Department of Transportation

April 21, 2023

SH 24G/Space Village Rd.
El Paso County

RE: Space Village Rd. Outdoor Storage _ PPR233

SHEET TITLE: **SITE PLAN**

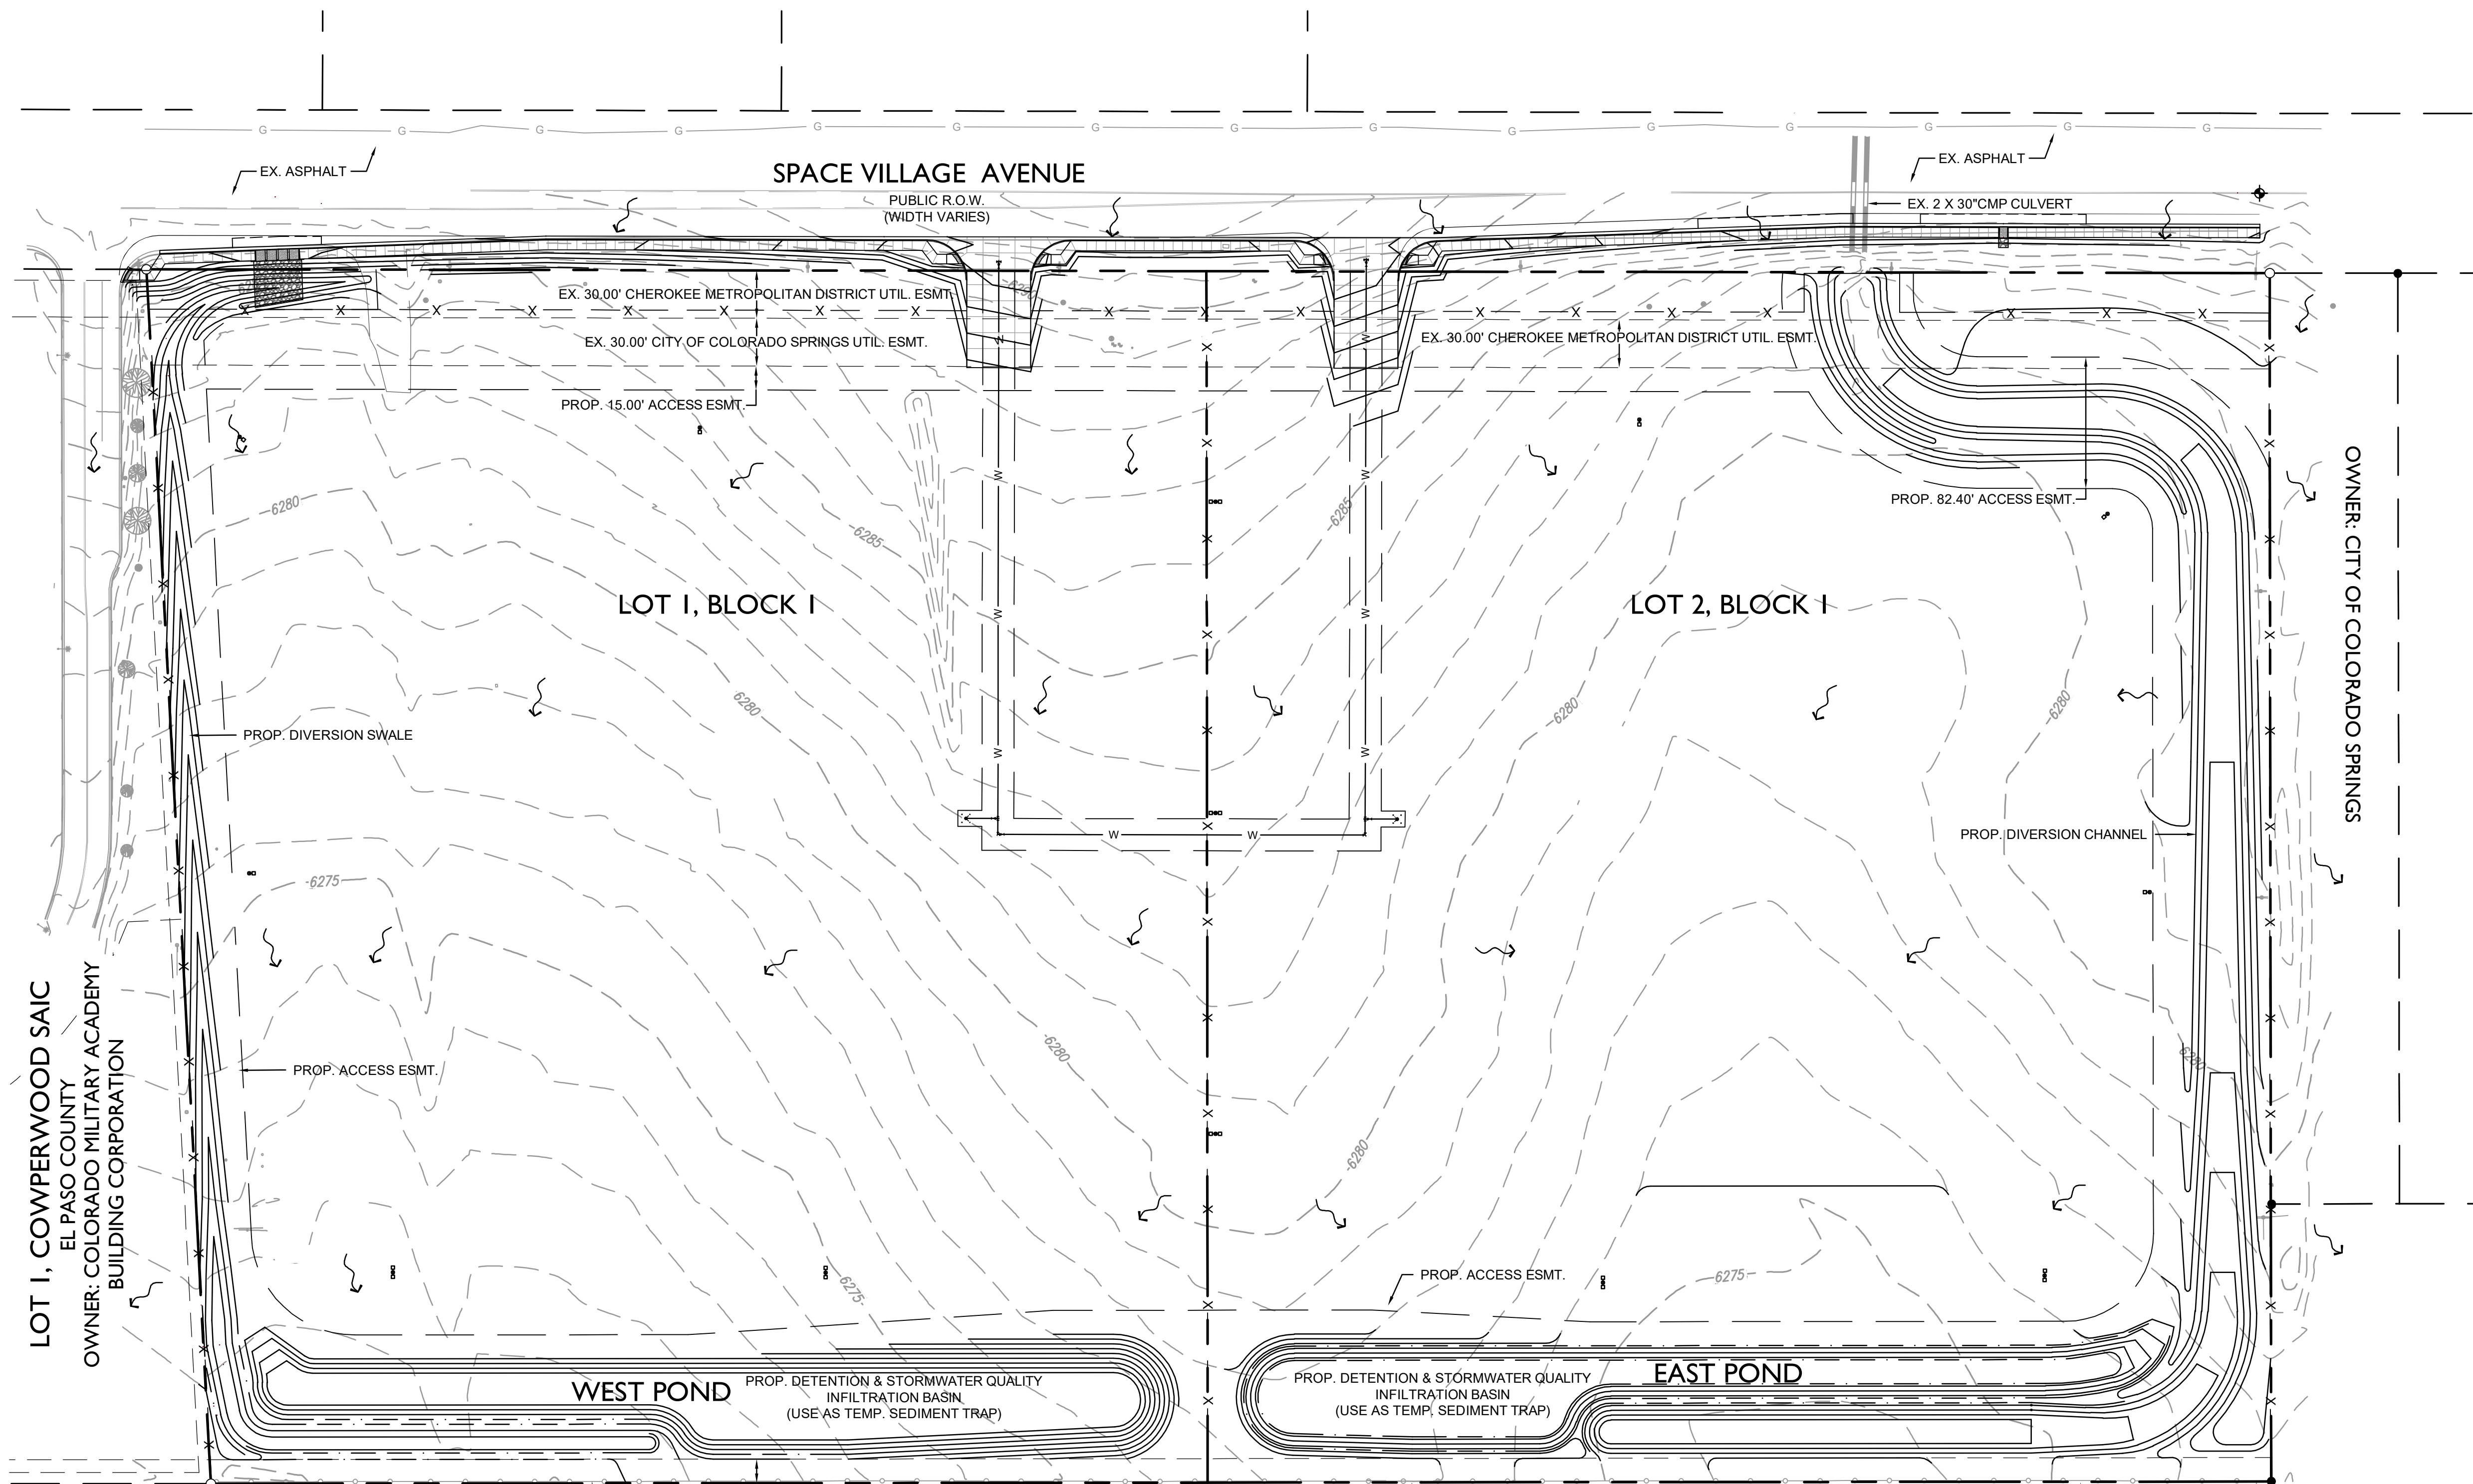
- CDOT Traffic recommends that the proposed east access point line up with the access to Storage Sense that is on the northside of Space Village. This driveway placement would eliminate a potential overlapping left between the two driveways.

The driveway has been relocated as recommended.
